From: Ros Parker
Sent: 07 January 2022 09:01
To: planning comments
Subject: FW: 2021/23487/HH - Souber Dairy (farmhouse)

From: [REDACTED] >
Sent: 06 January 2022 17:19
To: [REDACTED] >
Subject: RE: 2021/23487/HH - Souber Dairy (farmhouse)

drawing
 Existing Plan and elevations
 Scale 1/100

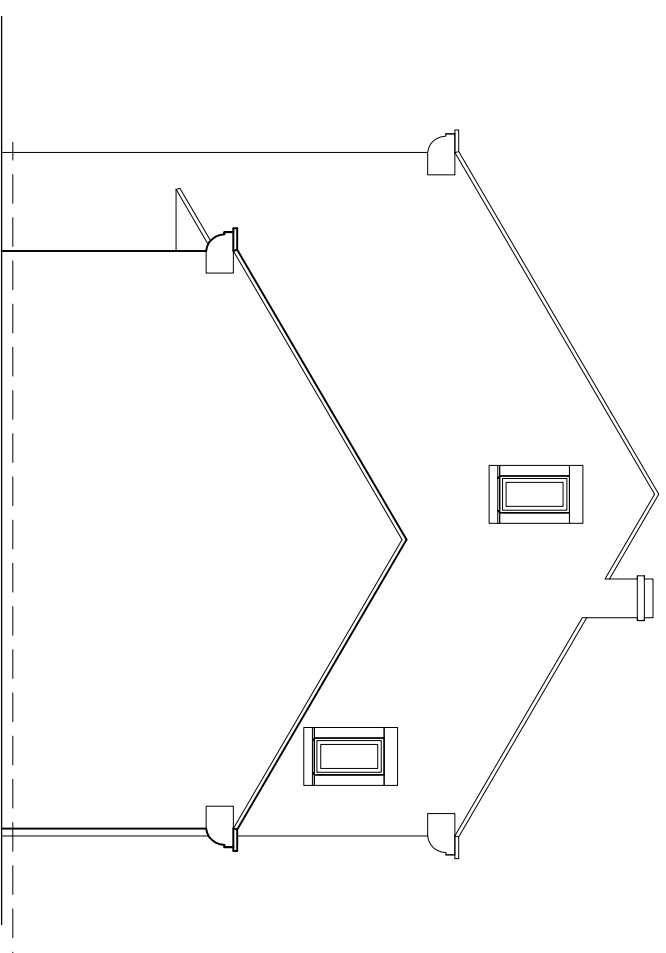
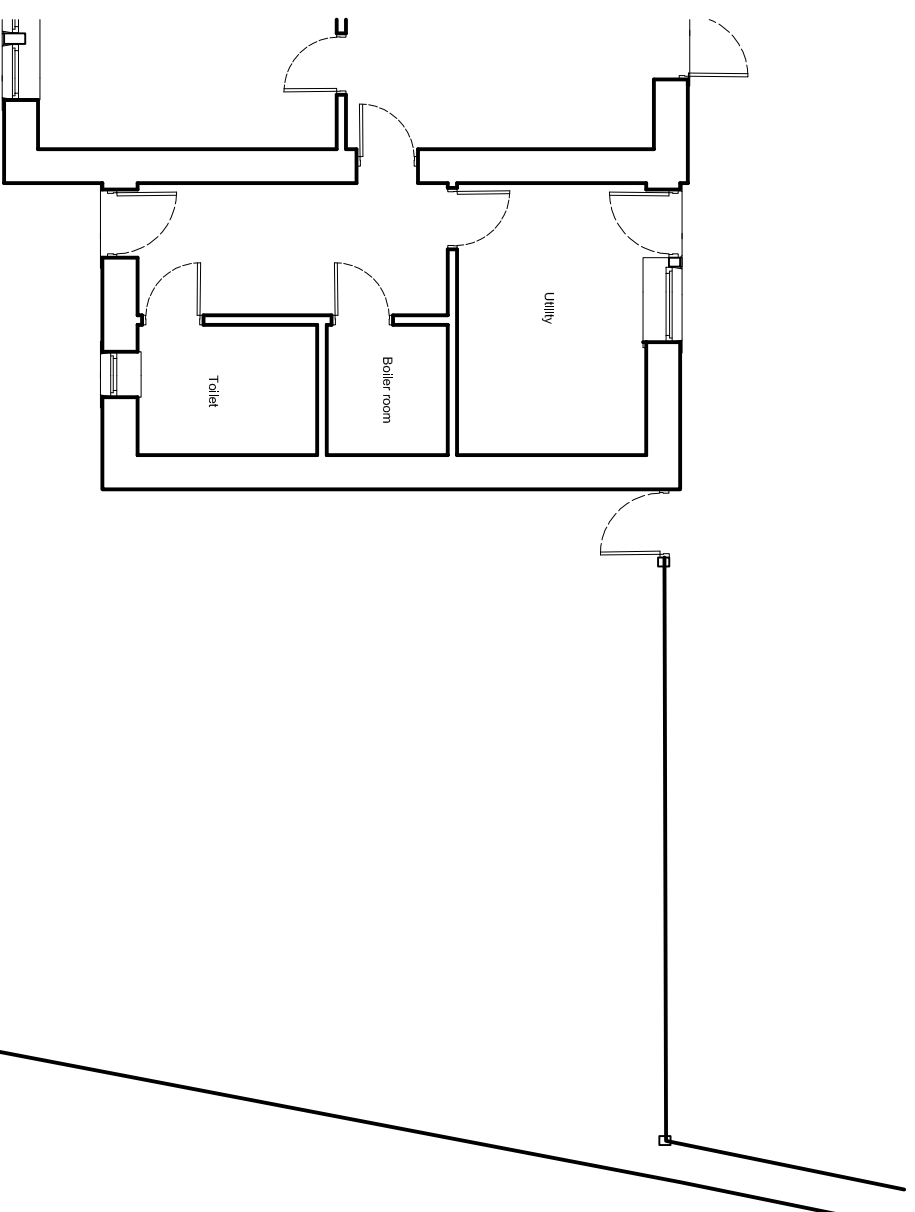
I haven't been on site but I have tried to assess whether the tree is worthy of a TPO. It looks to be of reasonable quality but I don't think it is very visible to the public and therefore a TPO might not be suitable. The garage looks like it will go into the RPA by a few metres. I would request an Arboricultural method statement to identify and mitigate any potential damage to the tree during construction.
